# KIRKLEES METROPOLITAN COUNCIL INVESTMENT & REGENERATION SERVICE

### DELEGATED DECISION TO DETERMINE PLANNING APPLICATIONS TO CARRY OUT DEVELOPMENT WITHOUT COMPLIANCE WITH PLANNING CONDITIONS PREVIOUSLY ATTACHED

Reference No:	<b>2024/70/92497/W</b>
Site Address:	42A, Station Road, Fenay Bridge, Huddersfield, HD8 0AD
Description:	Variation of condition 2 (plans list) on previous permission 2020/93329 (erection of one dwelling and associated works) to increase the finished floor levels and overall ridge height of the dwelling, amend the internal layout and to include a garage
Recommending Officer:	Lucy Taylor

#### **DECISION – VARIATION OF CONDITION REFUSED**

Elevations to Proposed Dwelling			
Grounds of 42a Station Road			
Fenay Bridge			
HD8 0AD			
Date	August 24	Dwg no	Scale
Dwn By		BR 01 B	A3 - 1:100

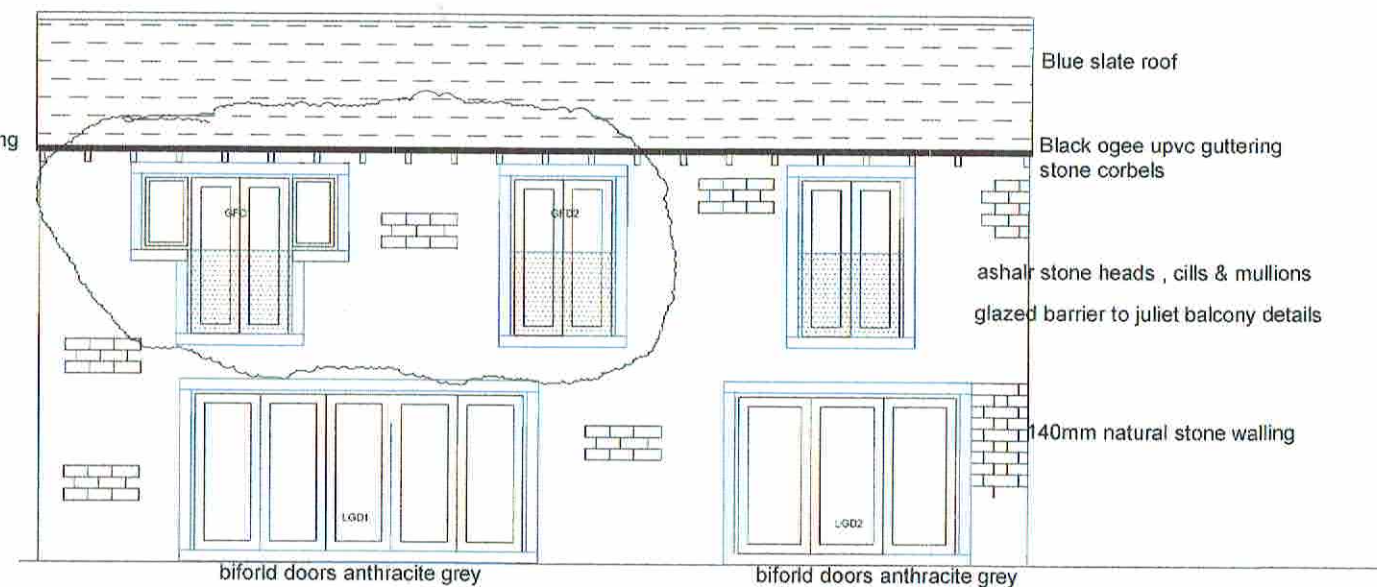
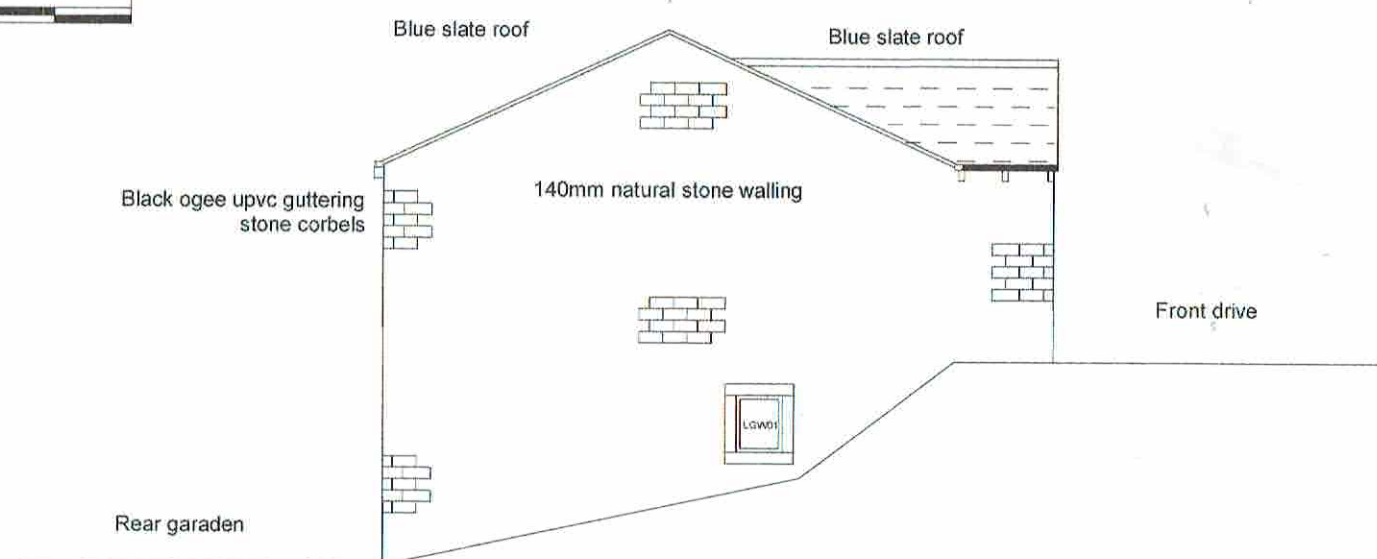
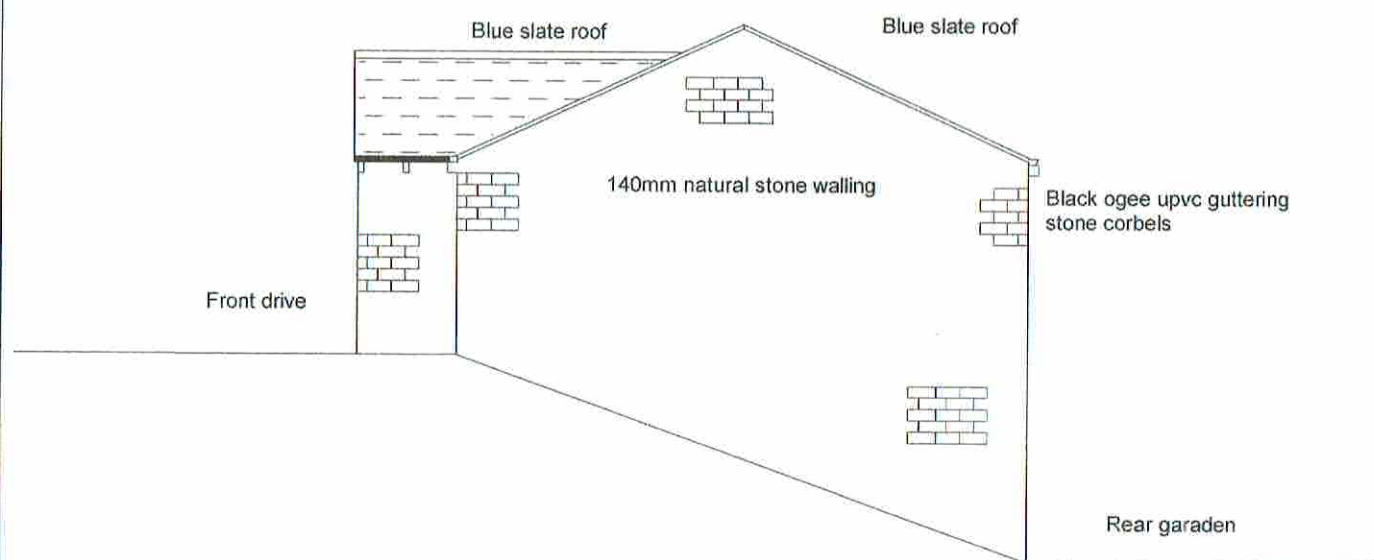
The proposed creation of accommodation in place of the car park over the lower floor would increase the width of the dwelling from 10 metres to 13 metres at ground floor level. It is considered that this increase in width would further reduce the openness of the site when compared with the design and architectural form of the dwelling previously approved under application 2020/93329, whereby the open car parking area helped in creating a sense of space around the dwelling. The increased width of the dwelling would move development even closer to the shared boundary with No. 42 Station Road, resulting in a separation distance of only one metre. This increased accommodation is concluded to be unacceptable from a visual amenity perspective, considered to result in a dwellinghouse which appears cramped within the site.

The proposed creation of accommodation in place of the car park over the lower floor would increase the width of the dwelling from 10 metres to 13 metres at ground floor level and bring the built form of the dwelling closer to the shared boundary with No. 42 Station Road, resulting in a separation distance of only 1 metre between the dwelling and this neighbouring property.

The site is located to a higher topographical ground level than No. 42 Station Road and therefore, the impacts of bringing development closer to the shared boundary would be exacerbated. The creation of additional accommodation would result in an overbearing impact to the rear elevation of No. 42 Station Road and to its private amenity space. It is noted that the increased accommodation would be sited directly adjacent to a patio area within the rear garden of No. 42 Station Road, suggesting that it would impact a primary functional area of the garden for the occupiers of No. 42.

Furthermore, the application site is to the south of no.42, and as such it would result to an increased loss of daylight to no.42 as a result of the orientation of the site, and the size and scale of the development proposal in relation to no.42. It is considered this impact would be further exacerbated by the fact the proposal upon land which is at a higher land level in relation to no.42.

This variation to the previously approved plans would result in the scheme being contrary to Policy 6 of the Housebuilders Design Guide SPD, which sets out that a new dwelling, located in a regular street pattern, that is two storeys or above, should normally have a minimum of a 2-metre separation distance between the side wall of the new dwelling and a shared boundary.

Proposed Garage
Grounds of 42a Station Road
Fenay Bridge HD8 0AD

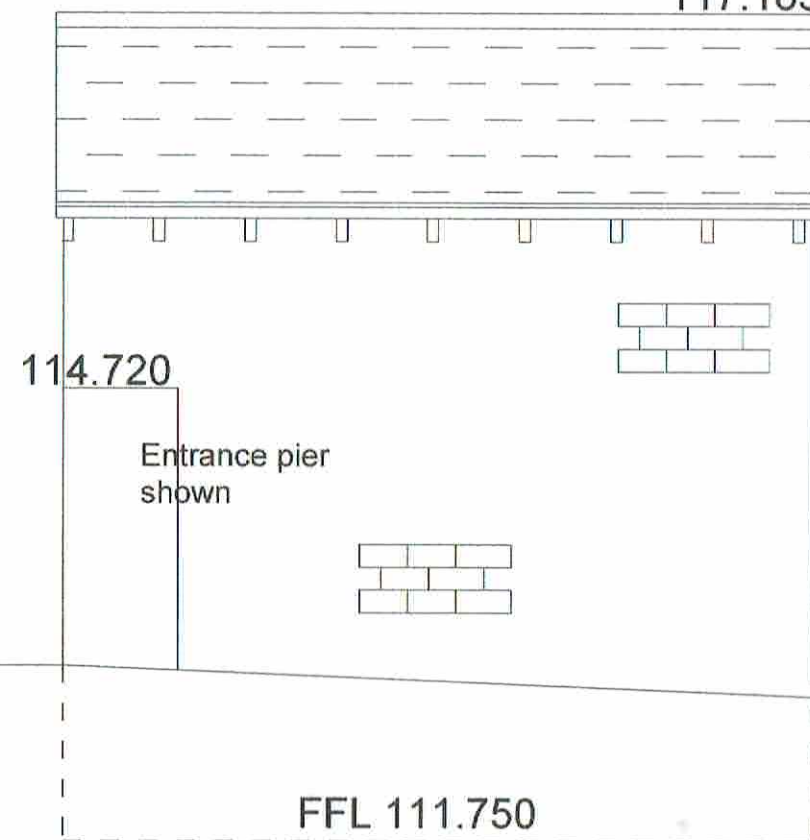
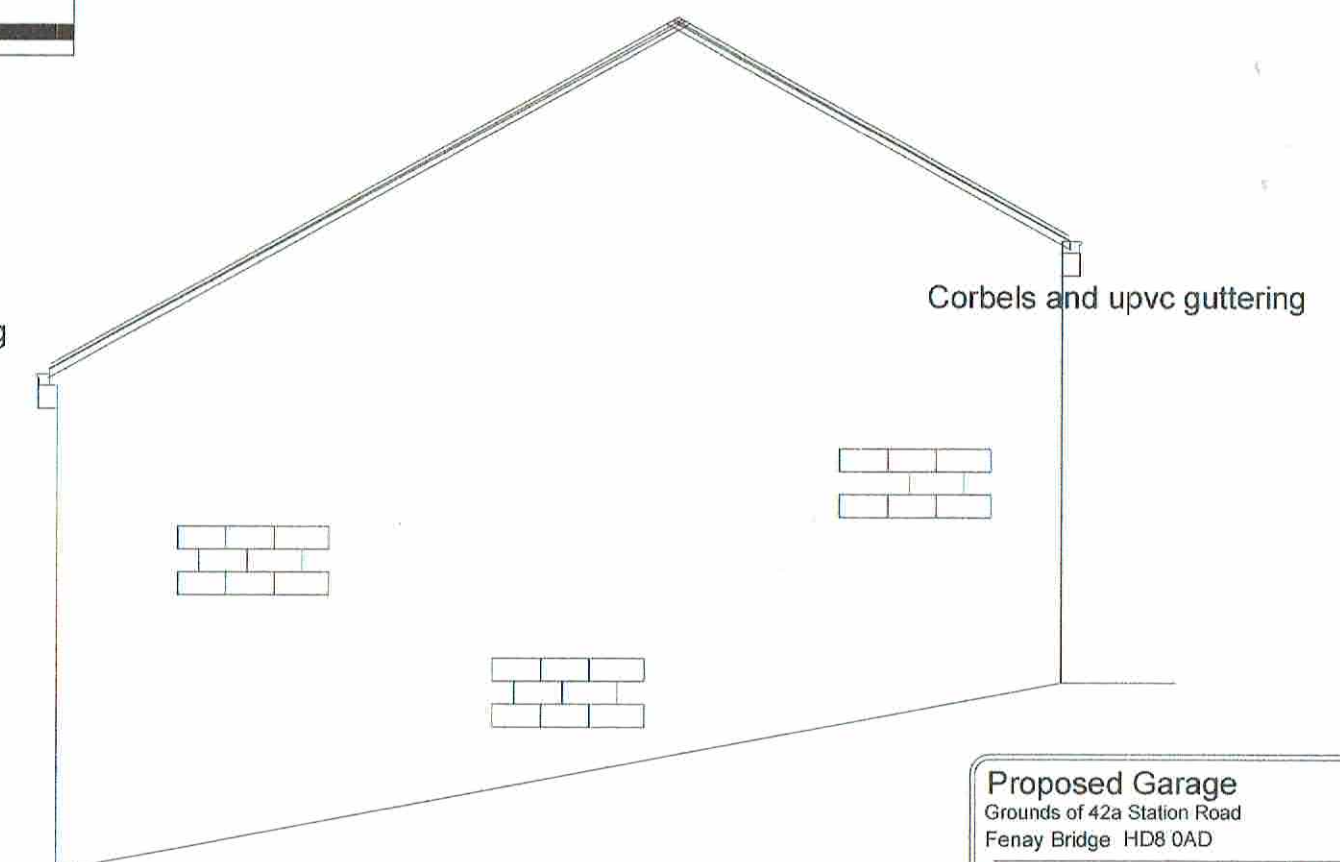
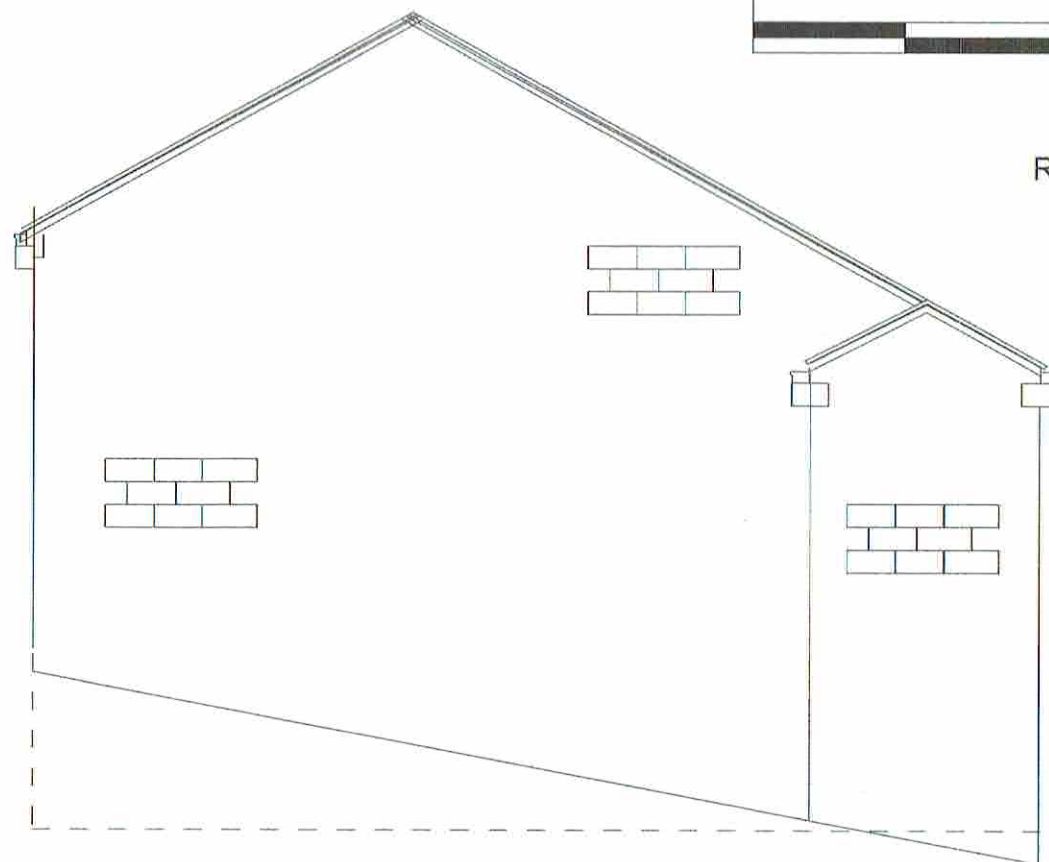
The proposed detached garage would be located to the front of the dwelling, to the long driveway which facilitates access from the highway to the dwelling approved under application 2020/93329 and No. 42A Station Road. Given the proposed siting of the garage, it is considered that it would appear as an overtly dominate stand-alone feature, when viewed from public vantage points along the highway of Station Road. The generous size / scale of the proposed garage contributes to its obtrusive appearance, to have a width of 5.9 metres, a depth of 5 metres and a height of 5.5 metres.

Given that the proposed garage would be set forward of the approved dwelling by approximately 19 metres and be of a dominating size / scale, it is concluded that it would be contrary to Principles 5 and 12 of the Housebuilders Design Guide SPD, whereby Principle 5 sets out *“careful consideration is given to accommodating garages and car parking within the development to ensure they are not visually dominant”* and Principle 12 sets out *“Ensure that any garages are set back from the front door of the house or are carefully designed in terms of materials so that they are not the dominant feature...”*

The garage would introduce a large amount of massing and brickwork which is in a prominent location which has no fenestration in place and would have a stark appearance in the street given it would not face into the street and would see blank elevations to the most prominent positions.
